34 EATON MEWS SOUTH : DESIGN & ACCESS STATEMENT

Project : 34 Eaton Mews South, (S73 Submission)
Date : Nov 2023

2.0 Changes Sought

Ref. 22/03408/FULL
External alterations to the building, including creation of a new roof terrace with installation of a new air conditioning unit at roof level.

1 Proposed Front Elevation
GE.00
1:50 @ A1

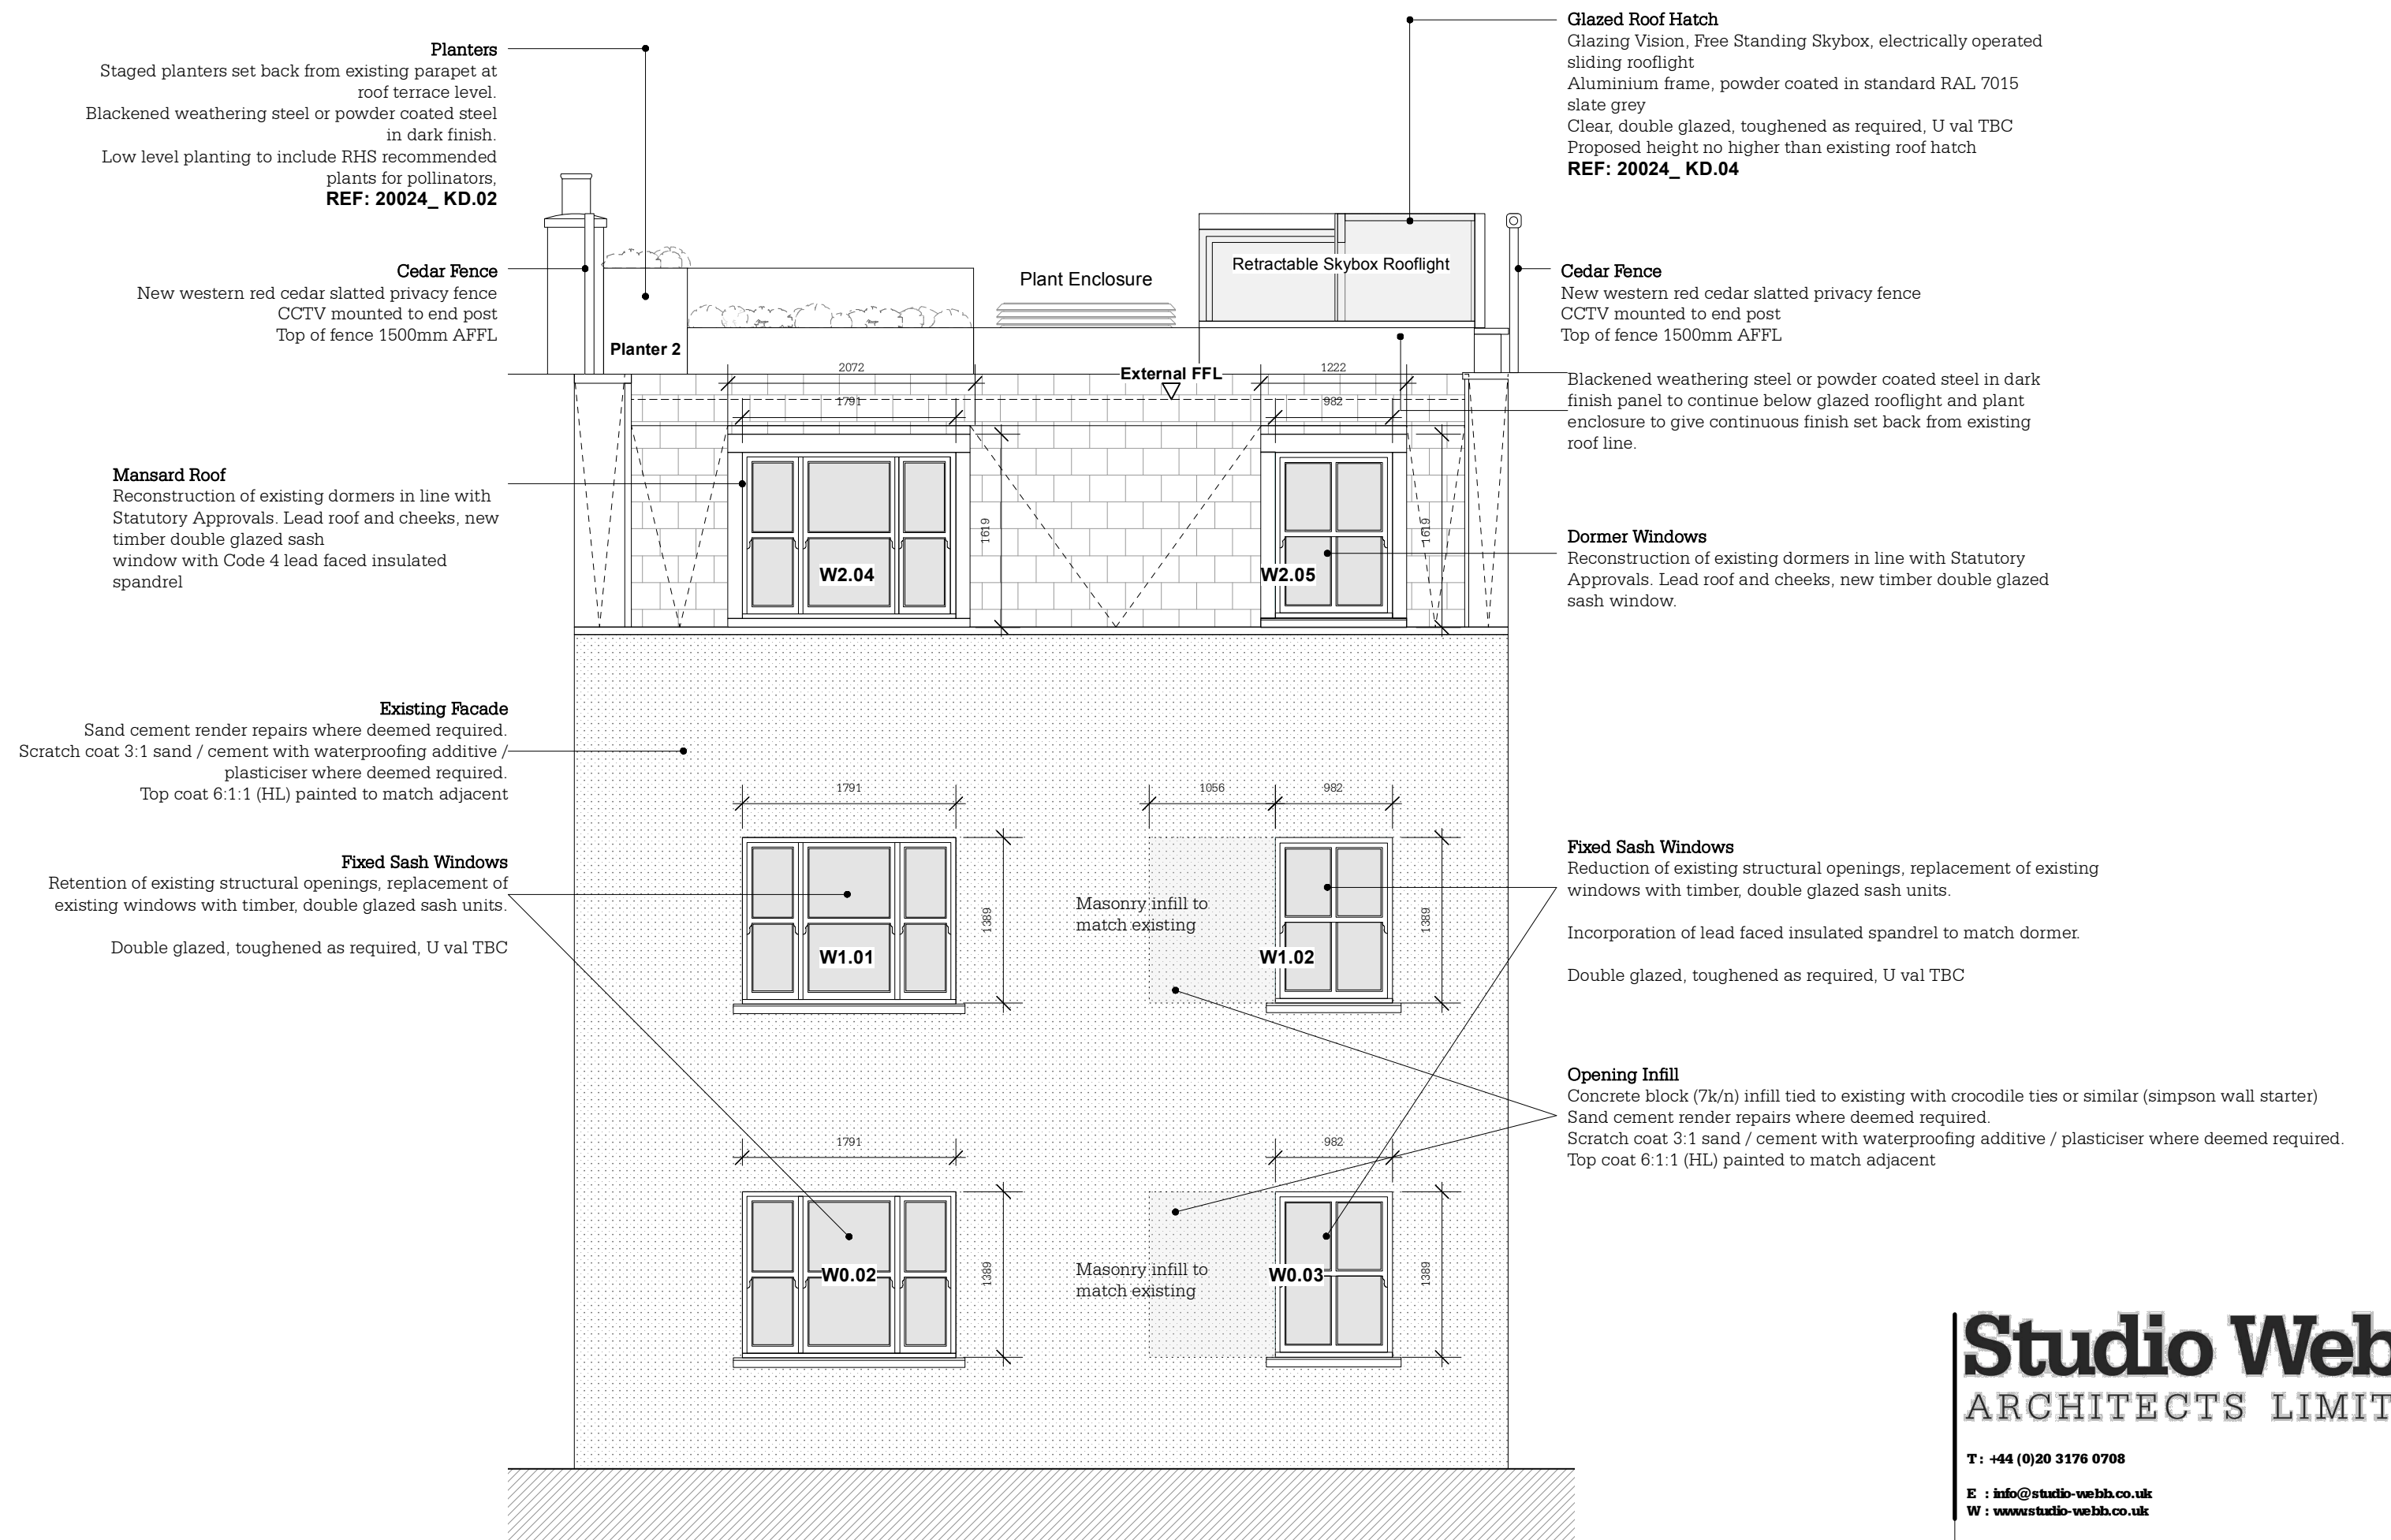
2. Installation of CCTV to front elevation - security provision

2. Installation of CCTV to front elevation - security provision

Discreet installation of camera modules to comply with the clients security requirements.

3. First floor window fenestration - reinstate as per original fenestration

4. Reinstate original render finish to ground floor - revert to original finish as masonry in poor condition to be exposed

4. Reinstate original render finish to ground floor - revert to original finish as masonry in poor condition to be exposed

Traditional painted sand and cement render to match that of the existing building. The previously approved painted brickwork is not achievable due to the condition of the existing brickwork which has been revealed on site. Spalling bricks and poor coursing joints would not allow for an aesthetic reflective of the conservation area.

5. First floor decorative balcony alterations - minor alterations to assist with functional use

Alteration of the existing metalwork to closer reflect that of the existing building prior to commencement of works.

This would supersede the detail previously approved as part of the discharge of condition process.

| DRAWING TITLE           | PROJECT NO.  | DRAWING NO.  |
|-------------------------|--------------|--------------|
| <b>Terrace Planters</b> | <b>20024</b> | <b>KD.02</b> |

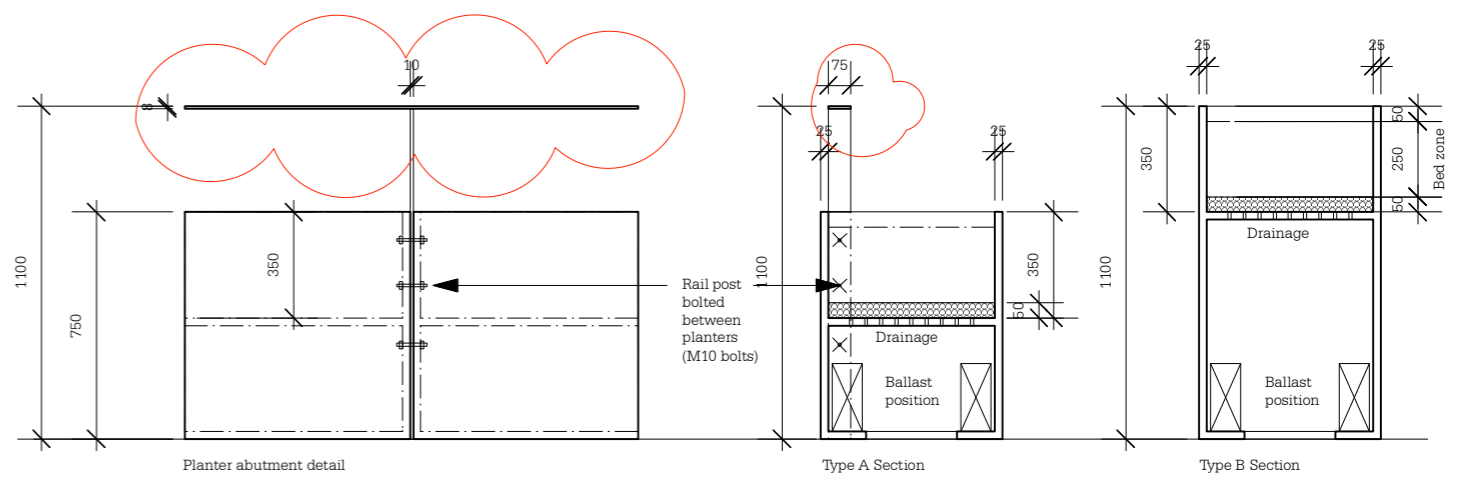
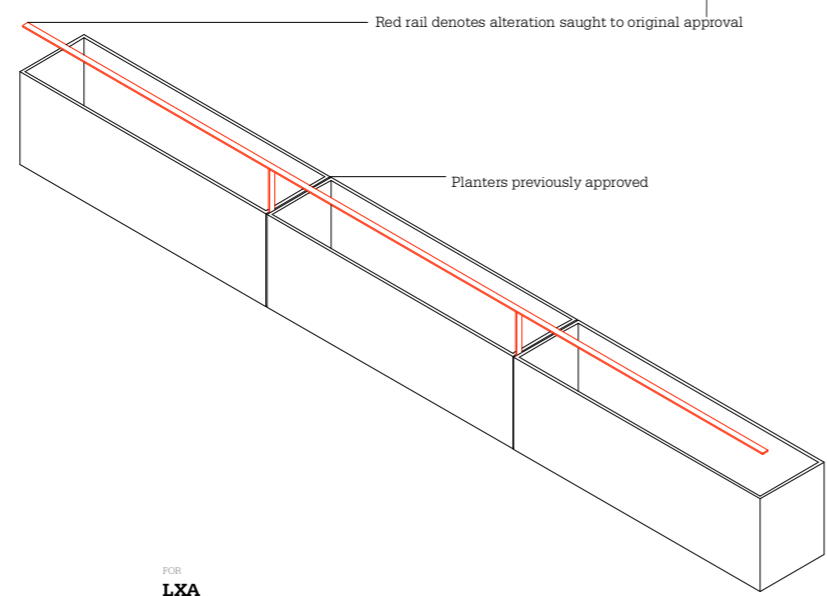
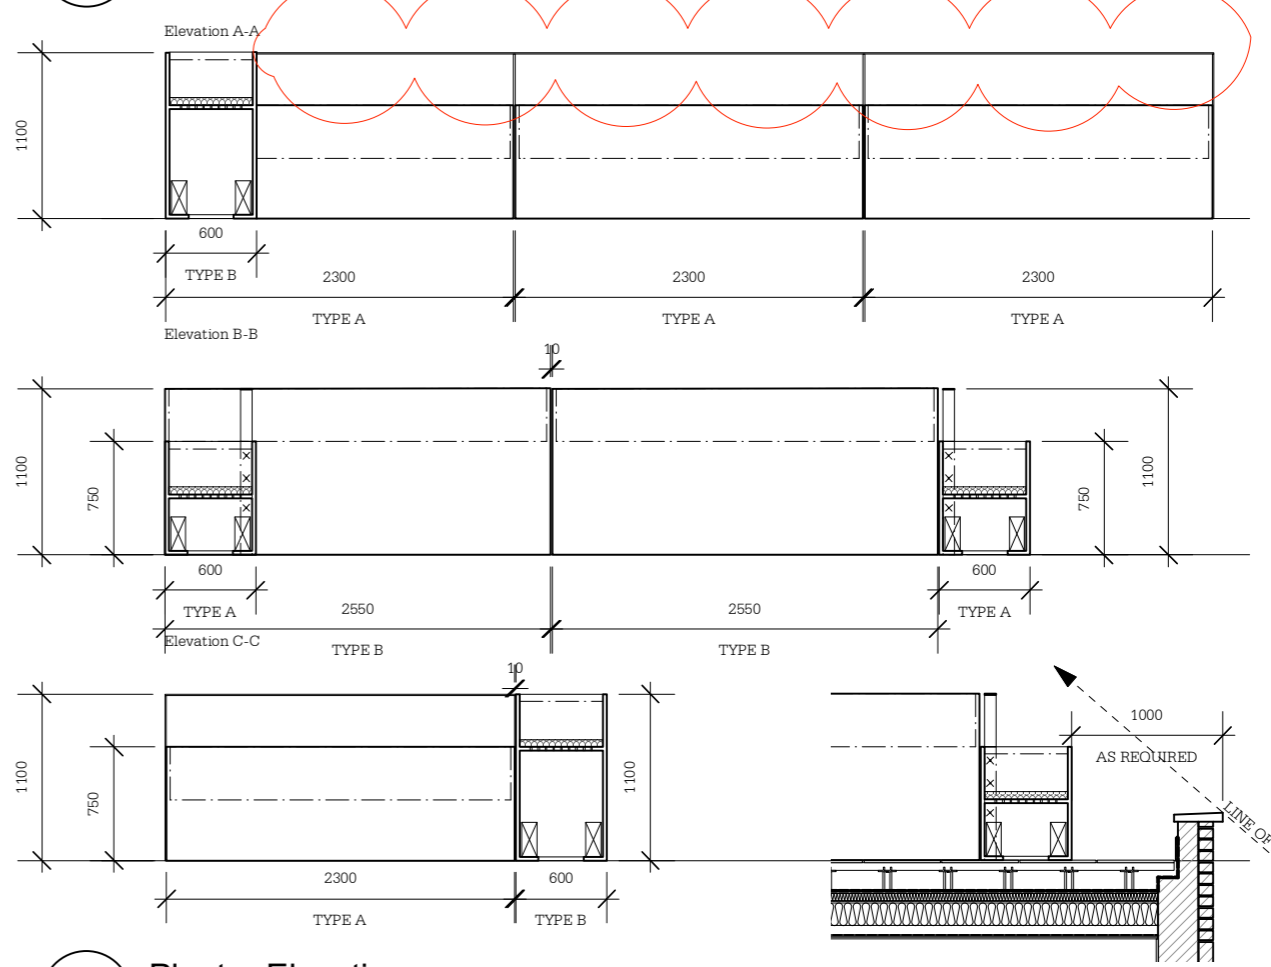
1. Handrail to roof terrace perimeter - fall protection re. building regulation compliance

Flat bar perimeter handrail detail to planters to ensure compliance with Building Regulations re. fall protection (1100 mm high).

The onlky change required is as shown in red - the addition of a single 10mm x 50mm flat bar rail.
